Our ref: MP08\_0241  
File: S08/01874/1

**Commercial/retail development, associated car parking and public domain improvements (MP08\_0241) at 86-96 & 100 Mount Street, North Sydney.**

## **ATTACHMENT 1 – DEPARTMENT OF PLANNING KEY ISSUES**

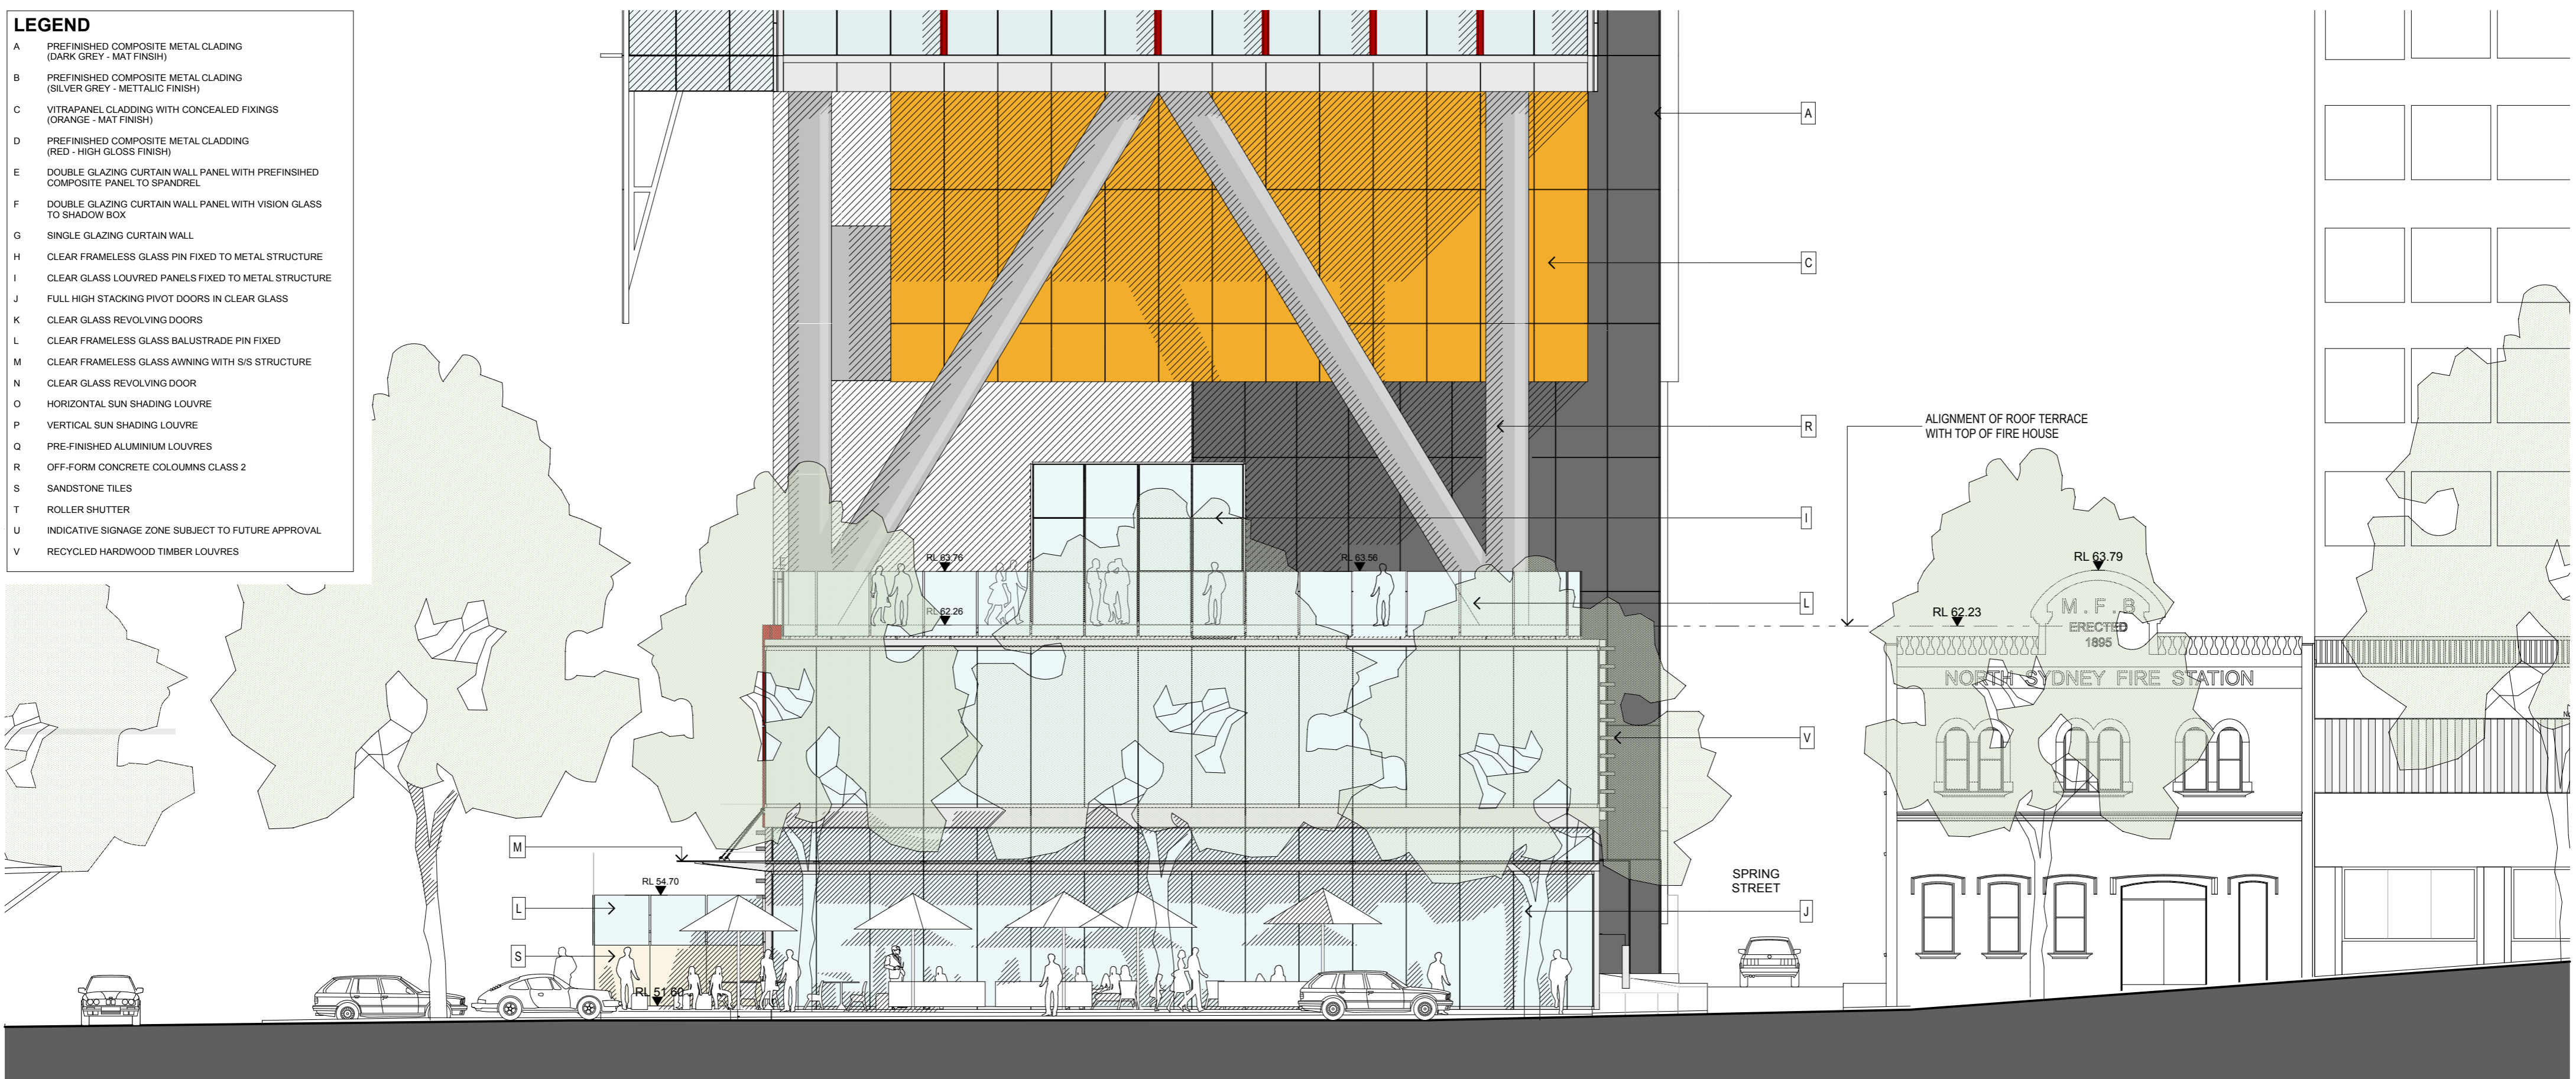
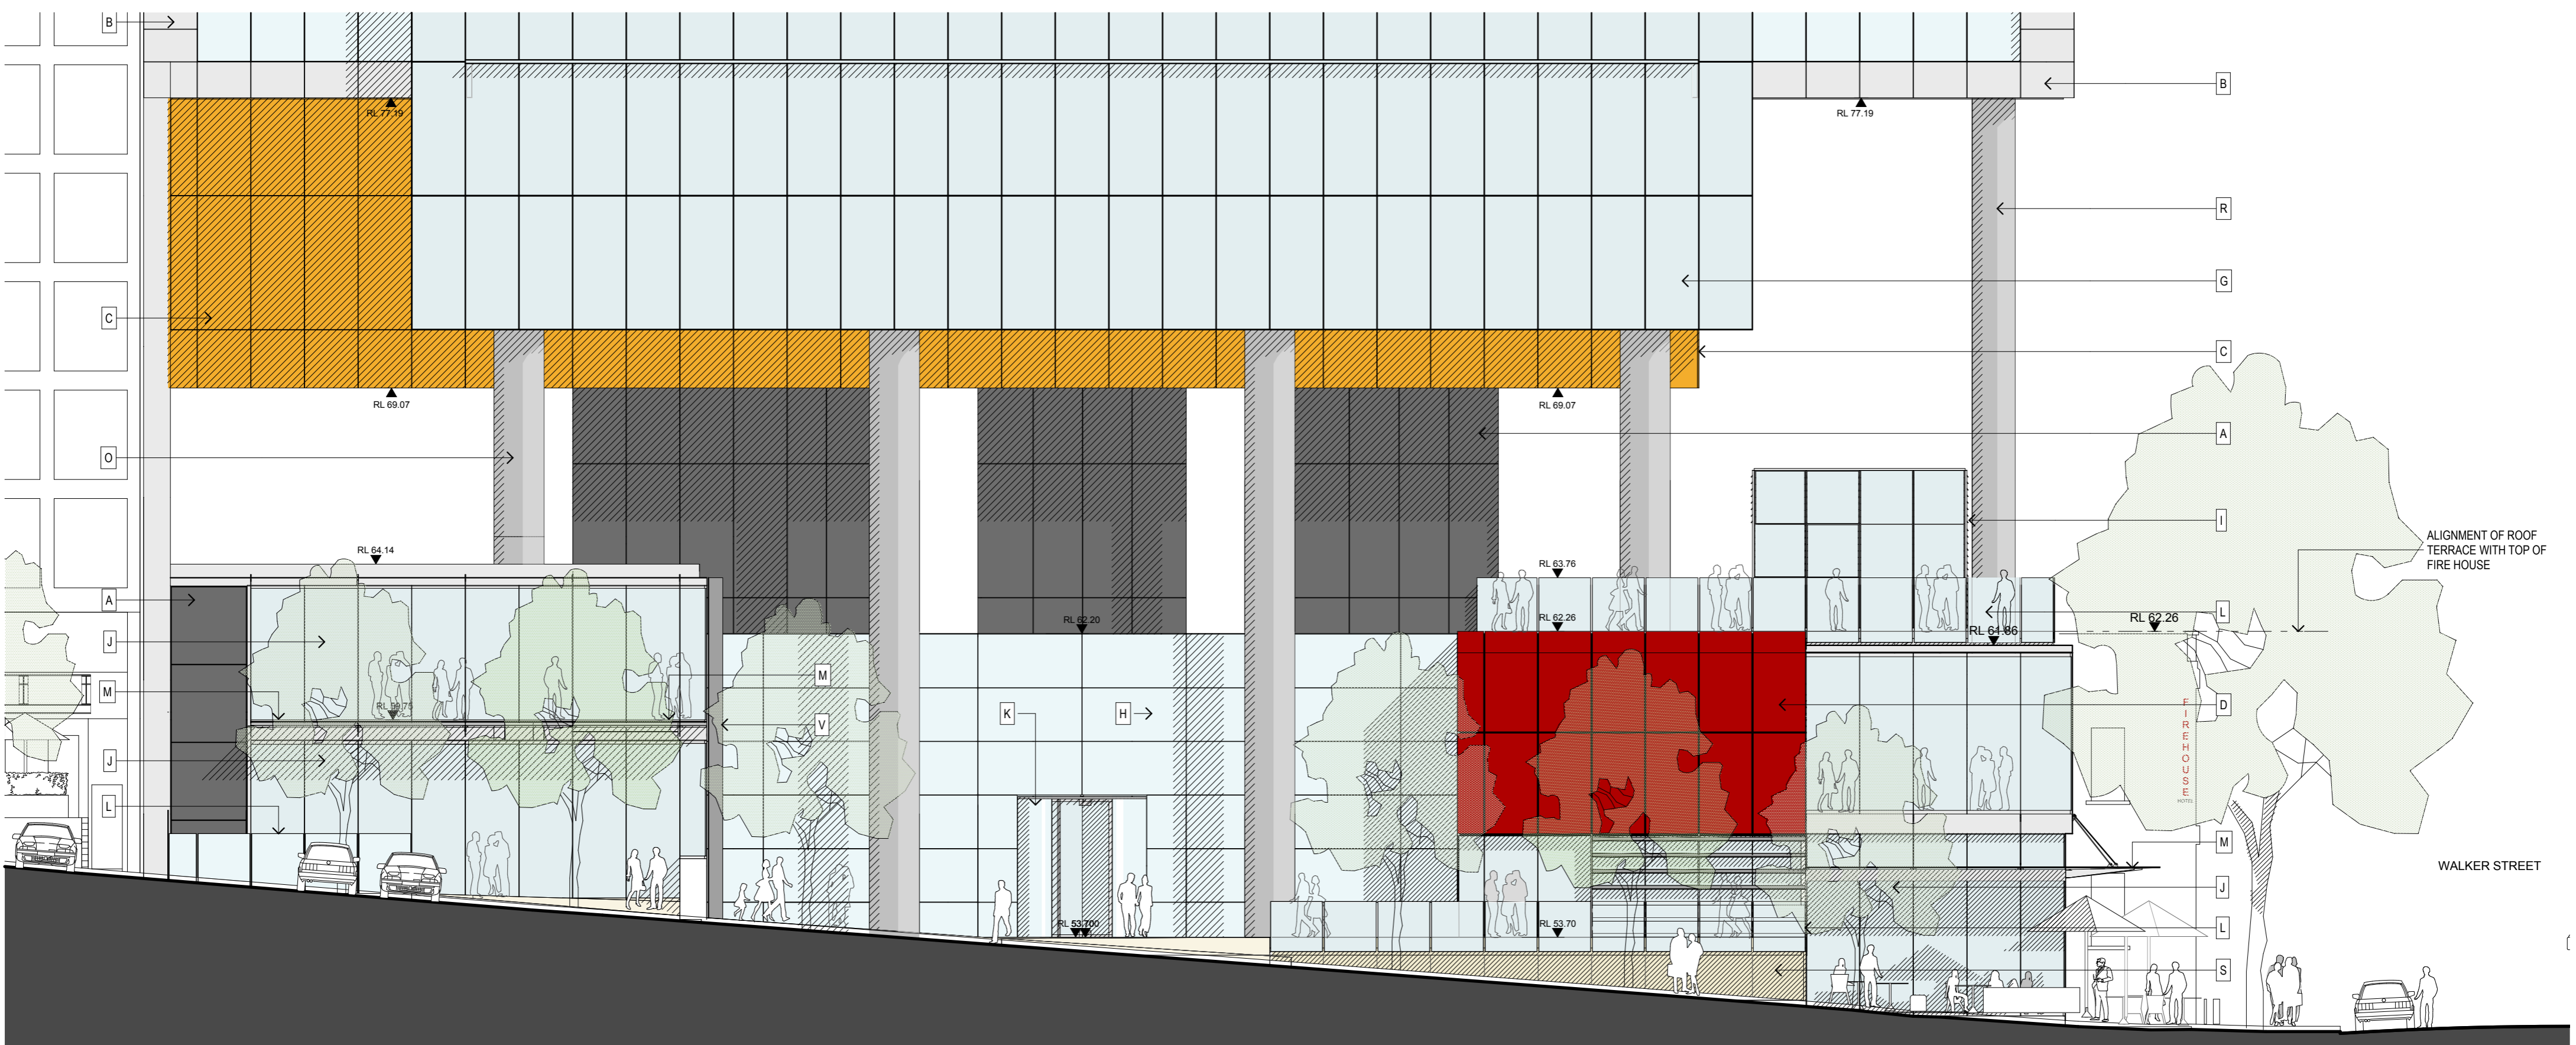
The Department is concerned with the setback treatment of the proposed building along Walker Street between levels 8 and 12. Further design resolution of the exposed structural frame (concrete columns) is required. This may involve consideration of other design options for this area.

The Department is concerned with the proposed projection forward of the tower at level 22 and above on the Walker Street façade, which is inconsistent with established setbacks and the prescribed setback controls. A site analysis is required demonstrating the existing setbacks of buildings in Walker Street to determine average building setbacks and should consider the current proposal for 88 Walker Street.
